SDC.CM.CP0439

23<sup>rd</sup> September 2024

**M60/M62/M66 Simister Island Interchange, Development Consent Order, 2024.**  
**Owner: Joseph Holt Ltd**  
**Property: Frigate Public House, Thatch Leach Lane, Manchester M45 6FW**  
**Plot Numbers: 1/33a & 1/33b**

Drawing number: HE548642 - ARD - LDC - SII_MLT
 Originator: ARD
 Volume: -DR- Z -0002

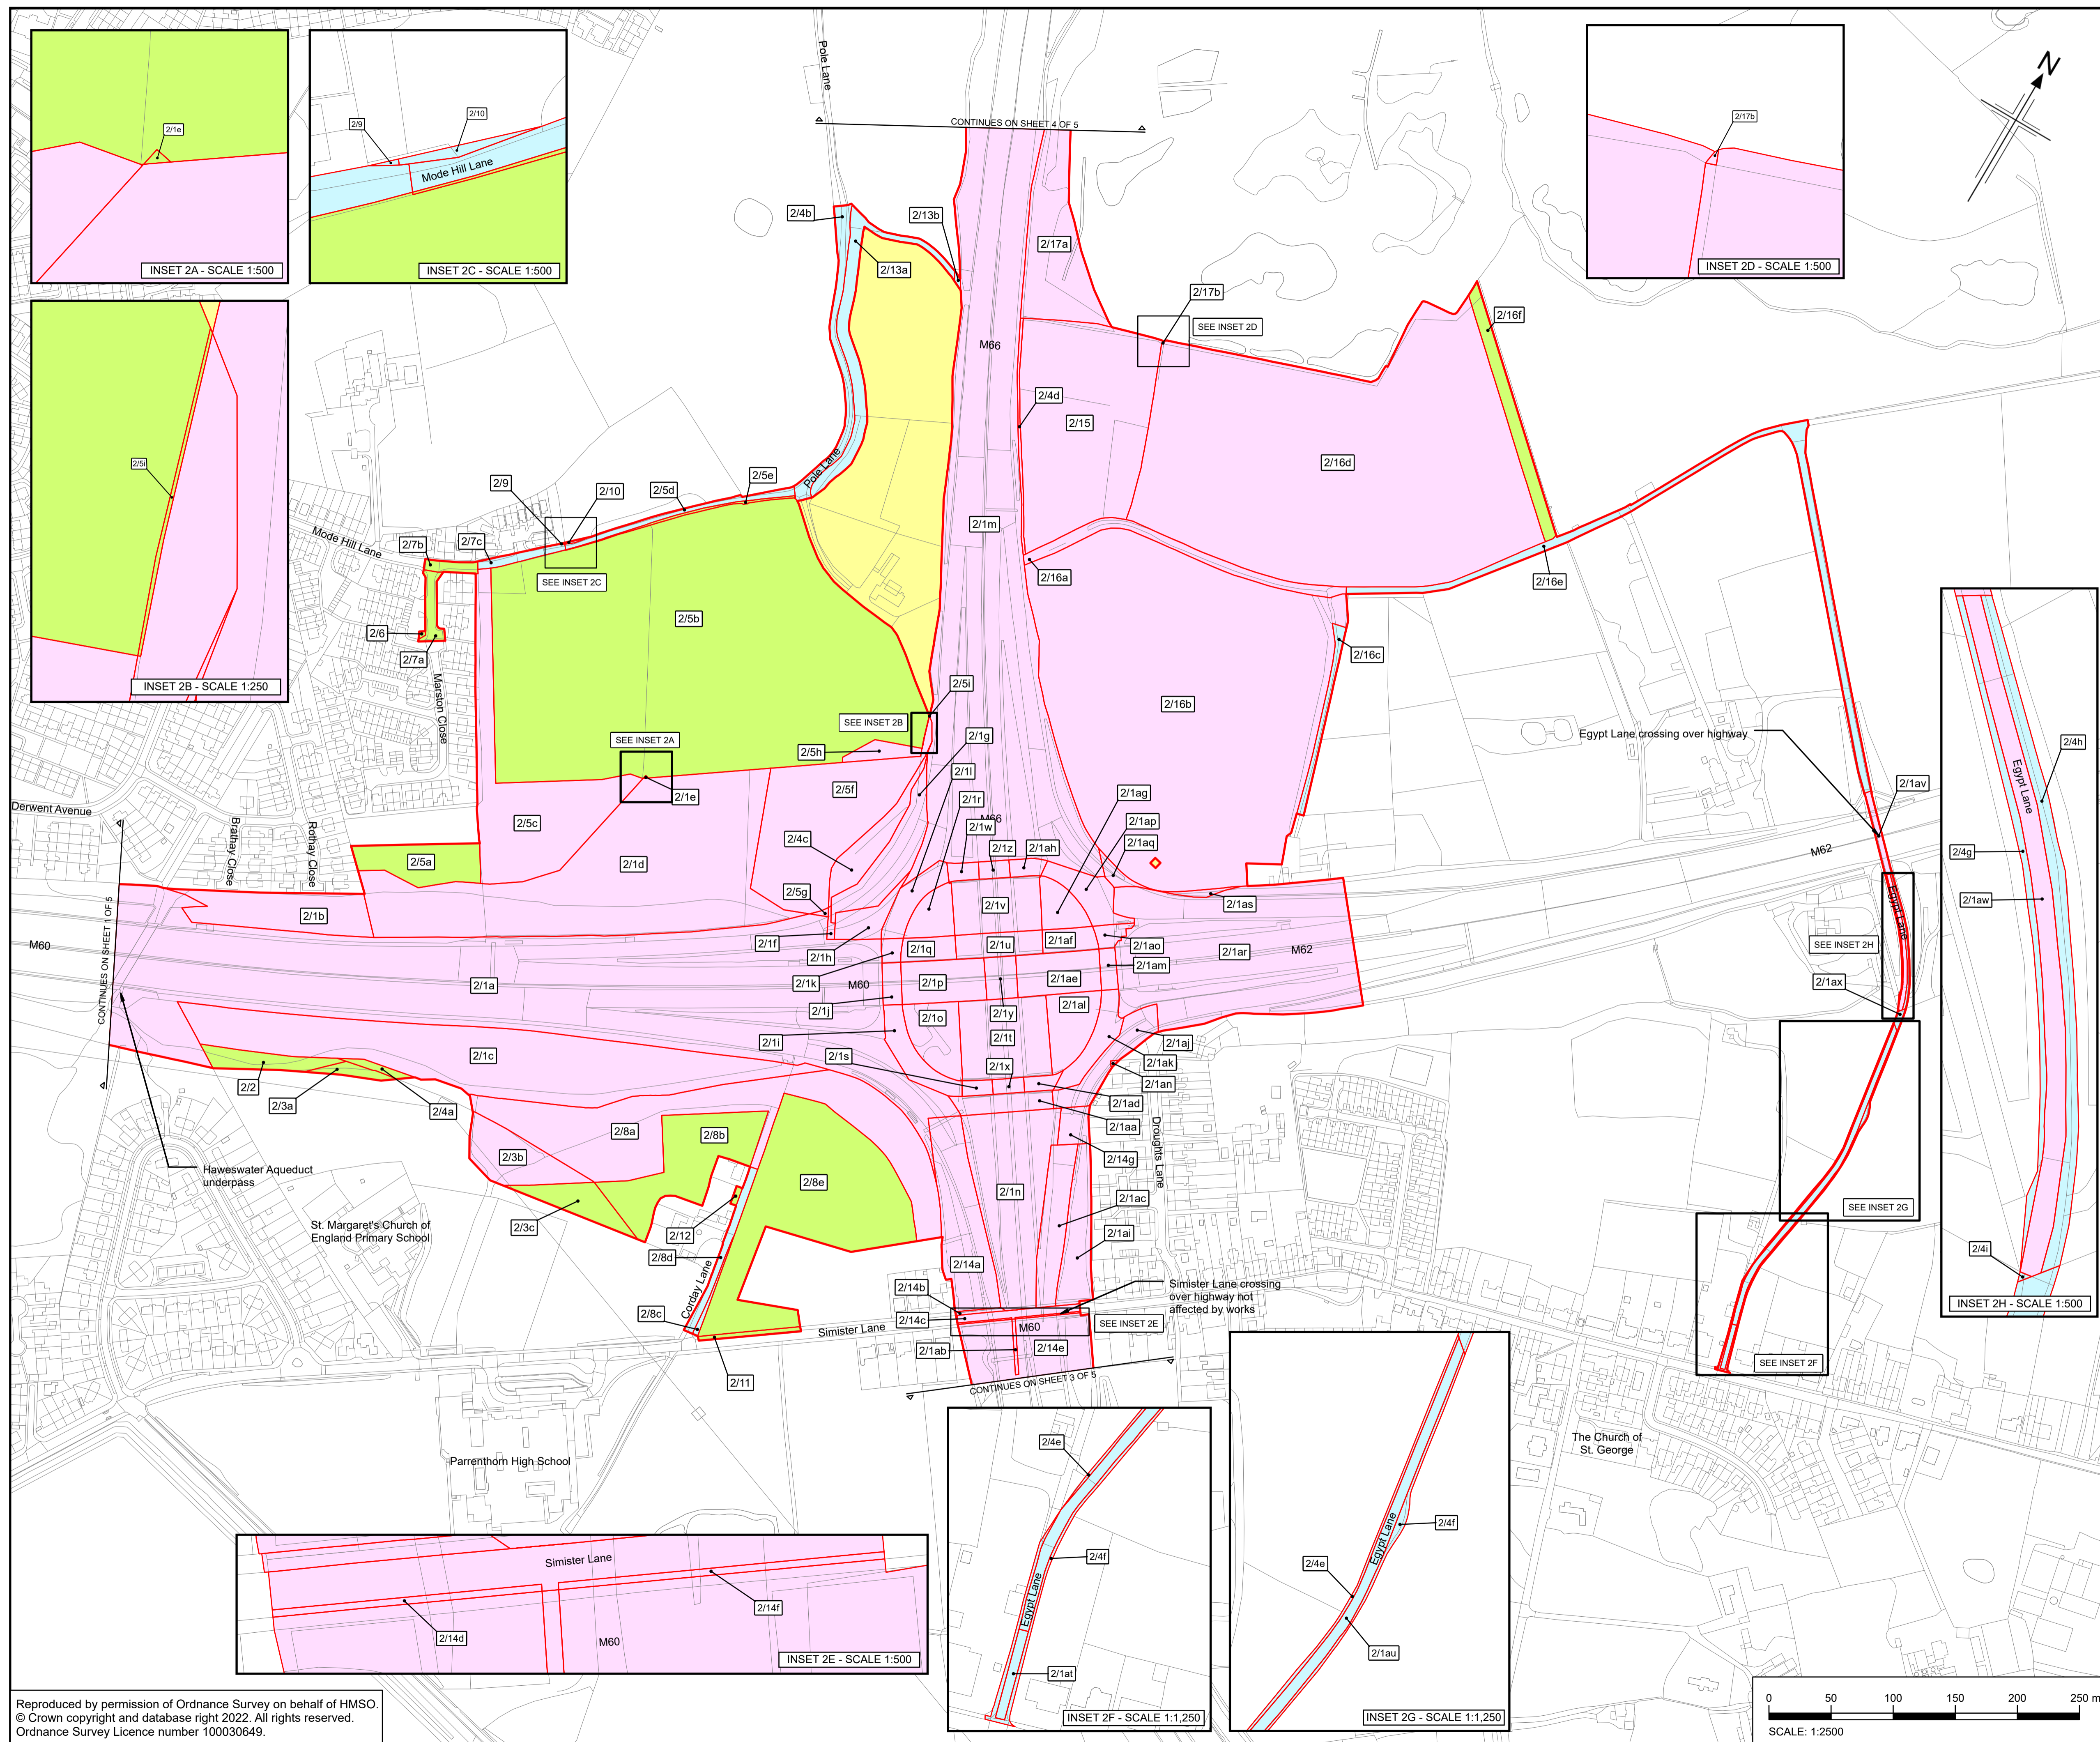
Appendix A of the Statement of Reasons fails to detail the justification for the acquisition of each land parcel. The justification relating to our client's land relates to the wider works to be carried out on this strip of road (within Sheet 1 of the associated plans), detailing the construction or alteration of portal and cantilever gantries. Appendix A does not provide specific justification as to why our client's land is required for the purpose of the scheme. With reference to the Work Plans (2024) below, the proposed cantilever gantry is positioned below our client's land ownership, and it is not clear as to why plots 1/33a and 1/33b are required to facilitate the construction of the gantry. Plot 1/33a sits just

above Highway's own landholding whilst plot 1/33b is located further back from the motorway network. There is no clear reason why the acquisition of these land parcels should be required for the construction or alteration of gantries.

With reference to the Land Plans (2024) below, National Highways' existing land ownership (highlighted pink) contains the above-mentioned technology cabinets. There is therefore no clear justification why Joseph Holt's land is required for access, when the scheme can be amended to provide safe access to the cabinets via National Highways' own landholding. This point is discussed further Section 2 of this letter. The permanent access rights sought represent the primary issue of concern for my client.

The requirement for access only proposes justification for the permanent acquisition rights over plot 1/33b (blue land). There have been no justifications provided as to why the temporary acquisition of either plot is required for the purpose of the scheme. Alternative arrangements can be made which would avoid these permanent rights being taken which would have the positive effect of reducing interference in land ownership and National Highways own compensation burden.

Highways England have provided no justification as to why the land is required for the development to be carried out to a satisfactory standard. This has not been provided for either the permanent acquisition of access rights nor the temporary loss of land. Furthermore, the extent of land taken within Joseph Holt Ltd.'s ownership is not proportionate to the purpose of the construction of a cantilever gantry nor providing access. The proposed acquisition will result in the temporary loss of a significant portion of the car park land and would have an adverse impact on the viability of the business and future ownership plans. The interference in private ownership rights is wholly disproportionate and needs to be reviewed.

The Order should be amended to exclude the land ownership of Joseph Holt (Plot 1/33a and Plot 1/33b) and at a minimum exclude the permanent land acquisition.

As discussed above, it has been proposed that Joseph Holt's land is required for access purposes. However, with reference to the plans above, there are clear alternative access options which have not been considered.

We would consider that safe access can be provided from the M60 by the maintenance of the proposed scheme or through alteration. The design of a road scheme should incorporate means of access to technology cabinets without requiring the acquisition of neighboring land.

Furthermore, National Highways' land ownership spans from Sandgate Road, to the east, providing direct access to the technology cabinets. National Highways are requested to fully investigate whether alternative access can be facilitated from Sandgate Road.

As stated in Section 5.3.5 of the Statement of Reasons, all reasonable alternatives to compulsory acquisition should first be explored. National Highways are requested to demonstrate why access cannot be obtained from their own existing land holding or via Sandgate Road.
